Department of Primary Industries

OUT13/19709

31 JUL 2013

Atlas-Campaspe Mineral Sands Project (SSD-5012) Response to exhibition of Environmental Impact Statement

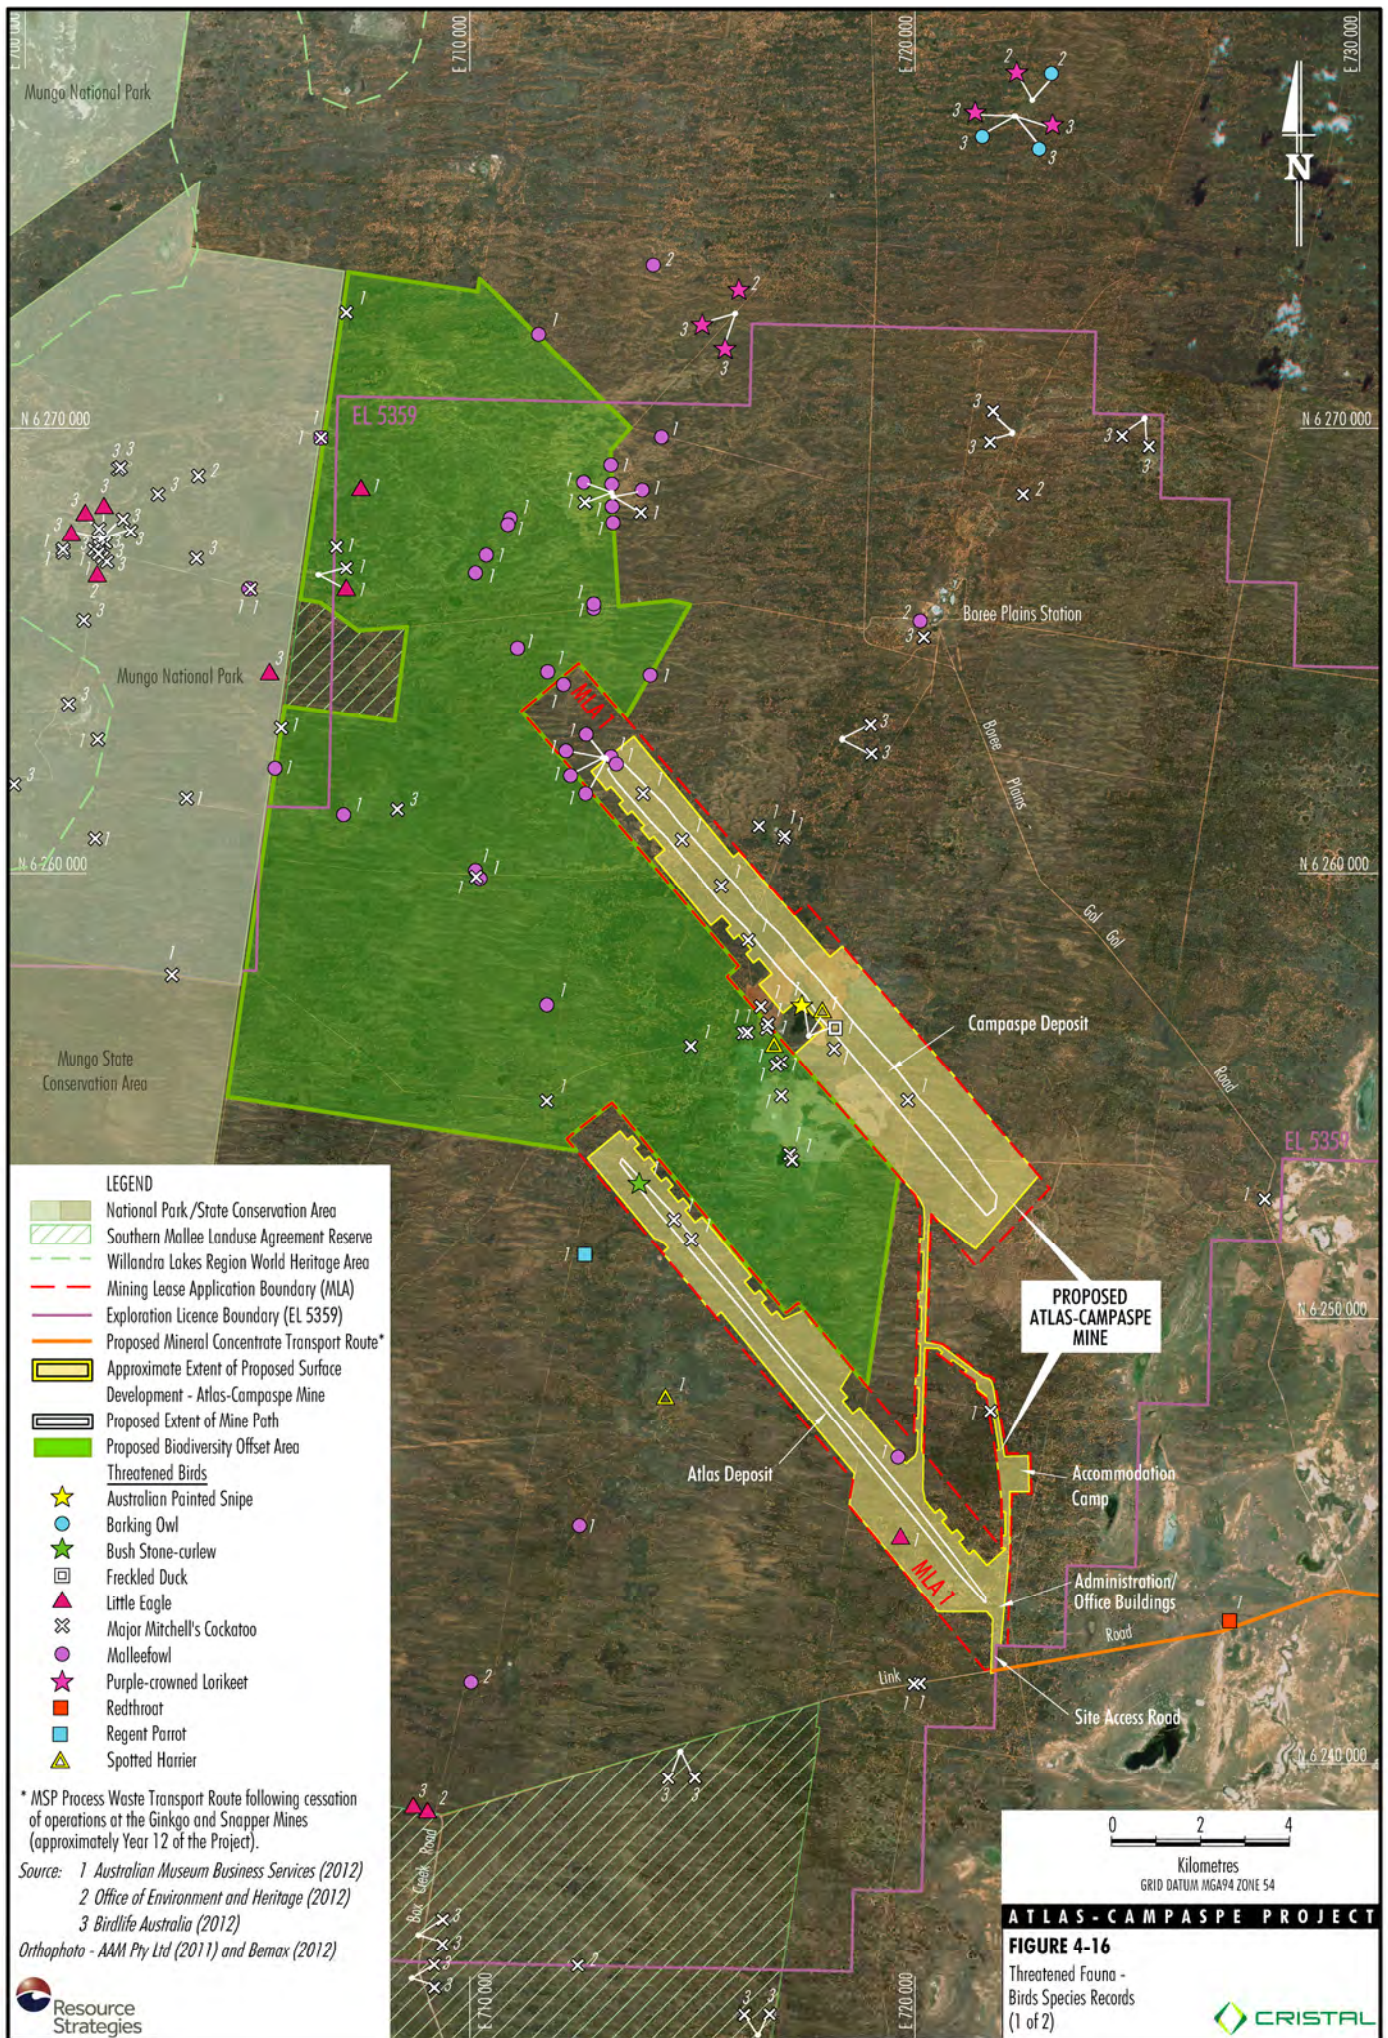
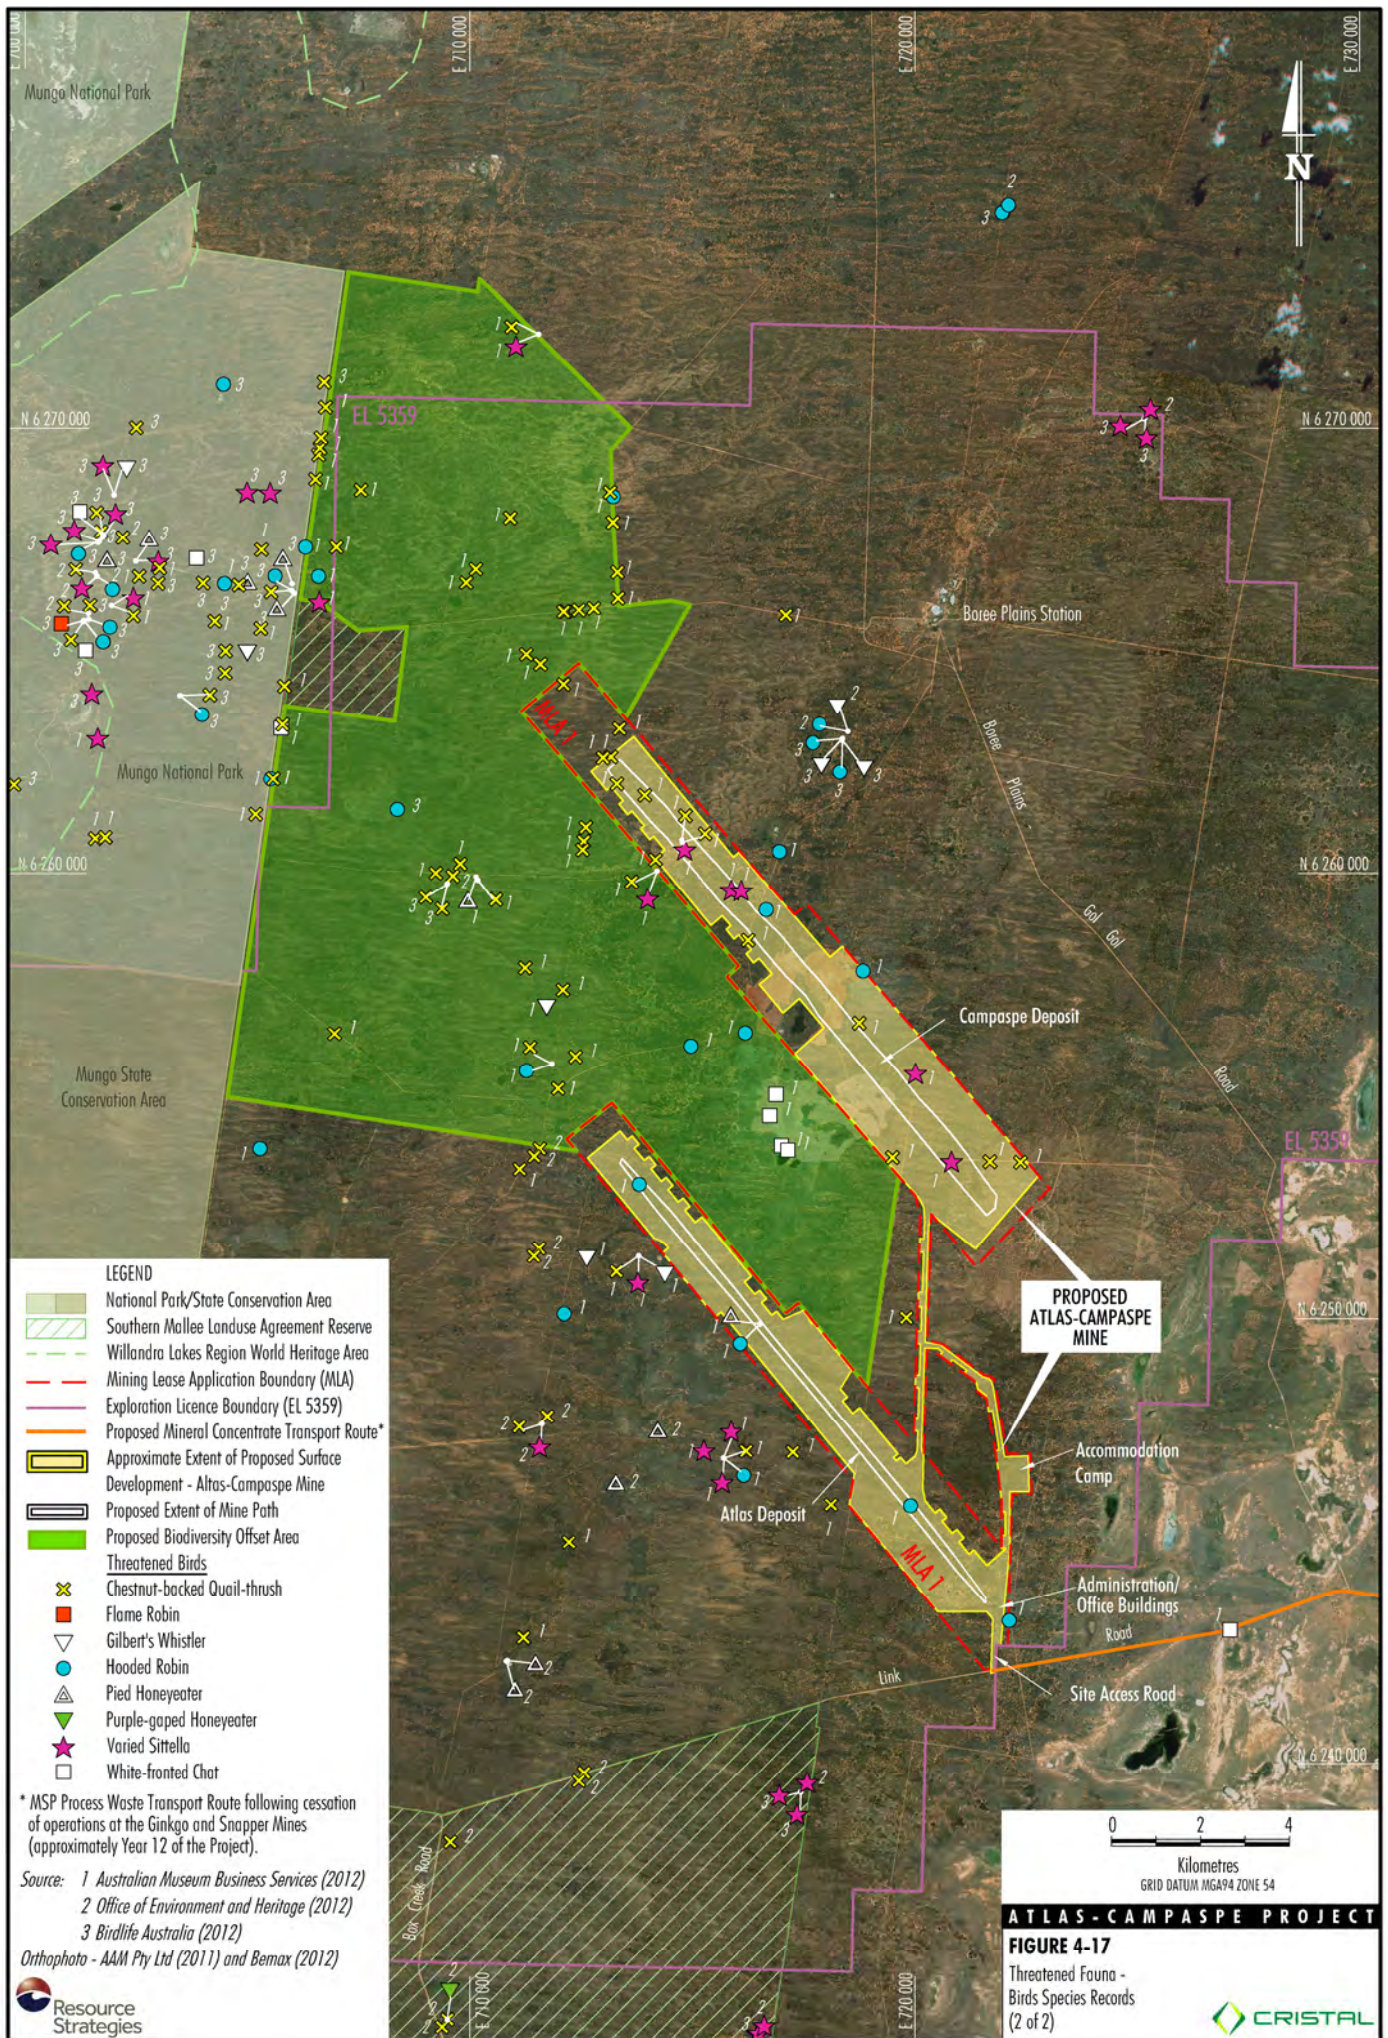
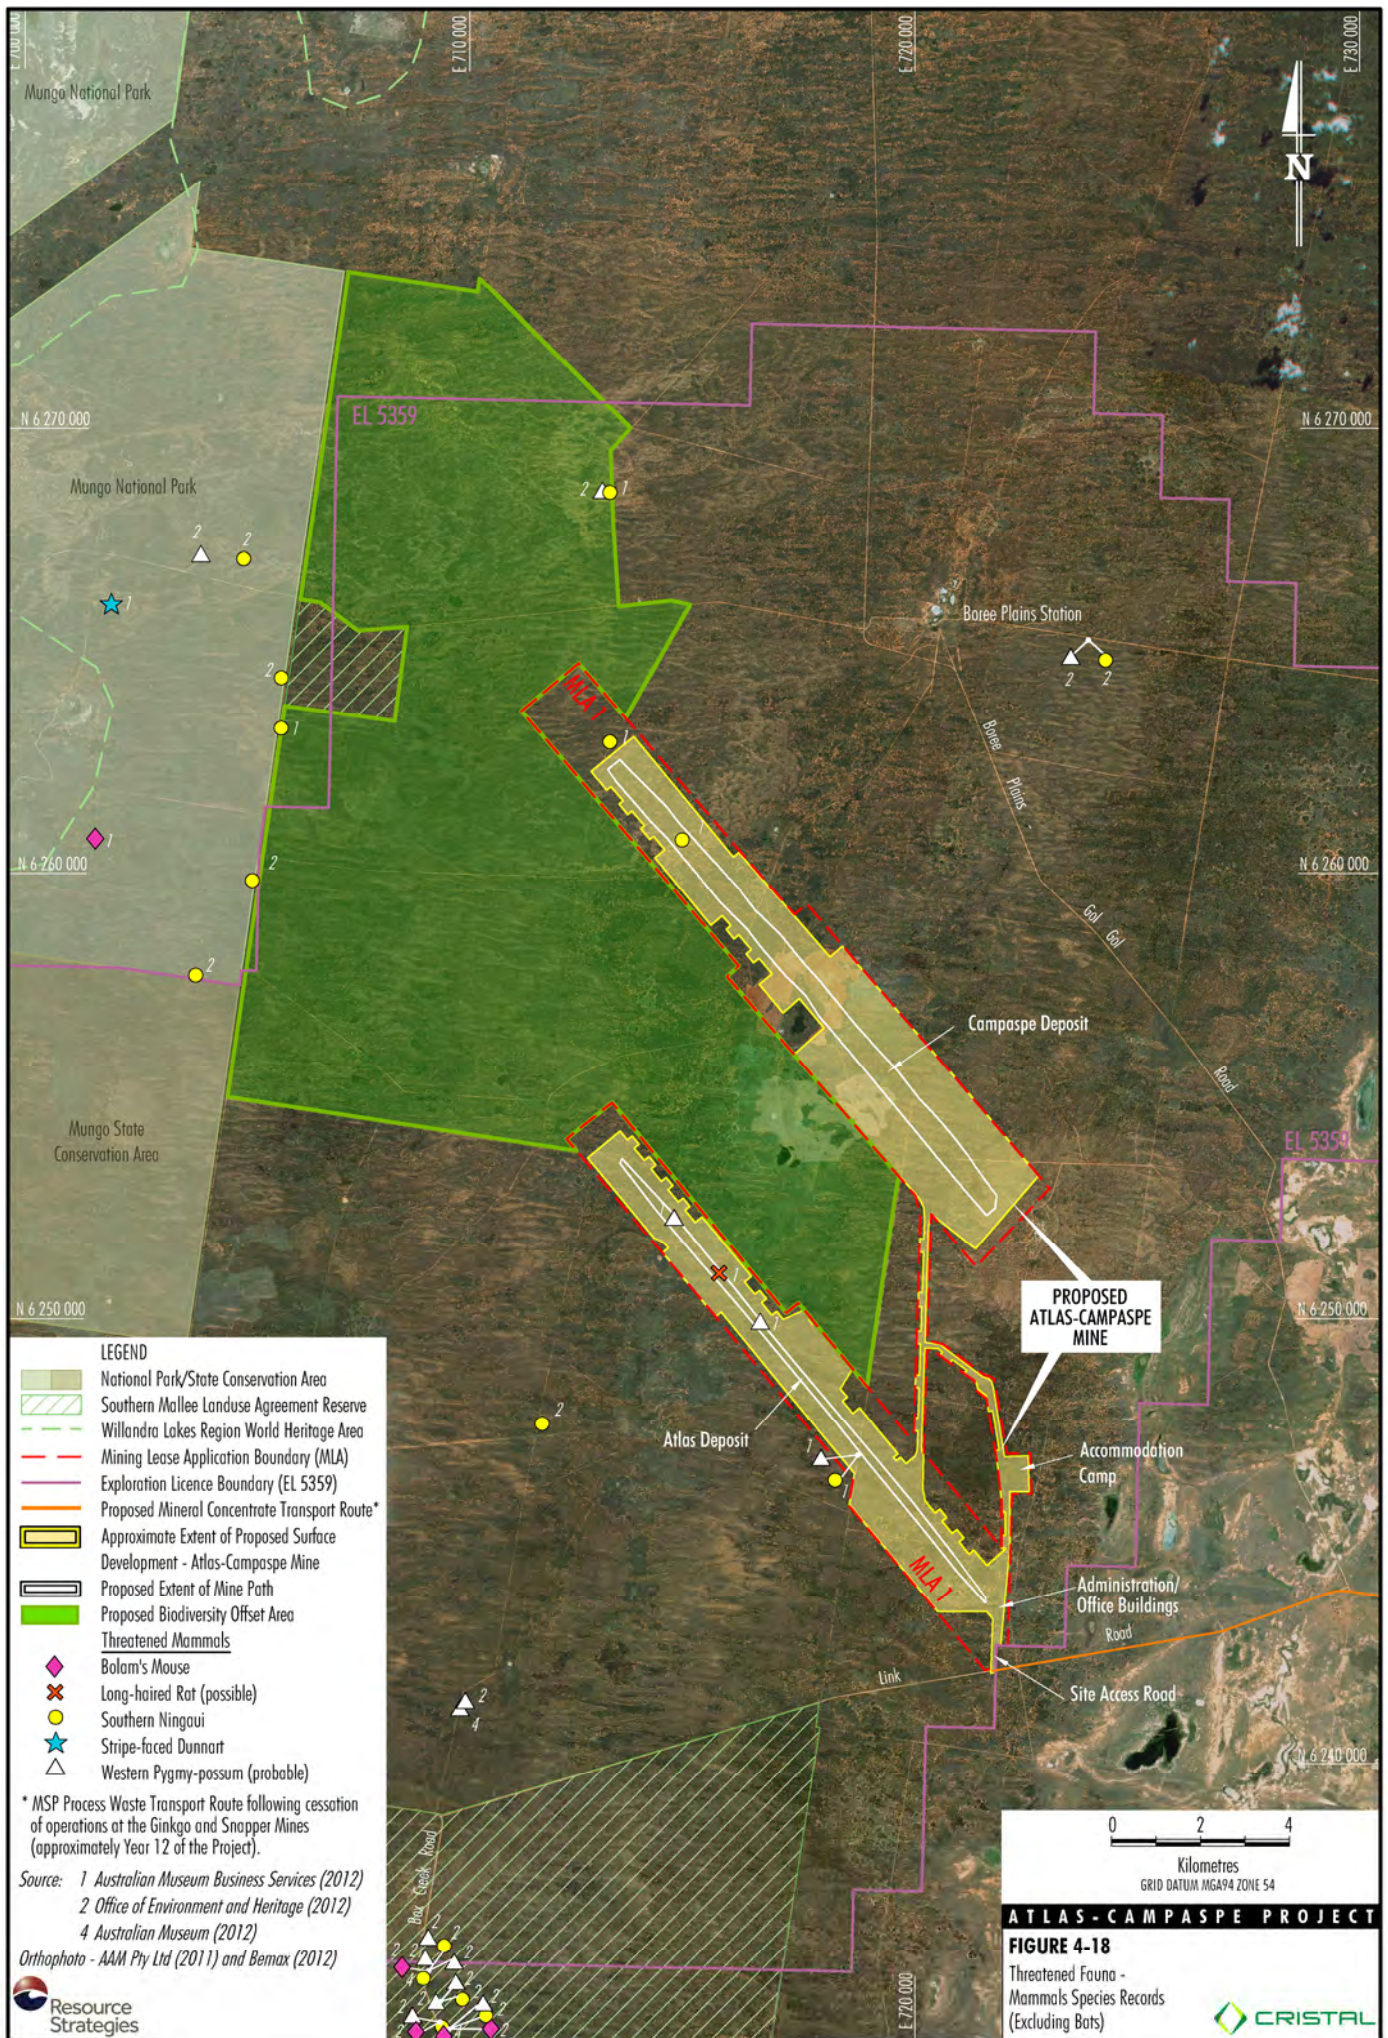
Travelling Stock Reserve (TSR) 583 (Gazetted 10 March 1884) traverses Lot 614 in Deposited Plan (DP) 761601. The proposed mine development and biodiversity offset area, shown in Figure 4-13 (Section 4, Page 4-46), is likely to encroach upon the TSR. In which case, the proponent will need to negotiate with the relevant Livestock Health and Pest Authority (LHPA) regarding site access and occupation. This is not stated in the EIS.
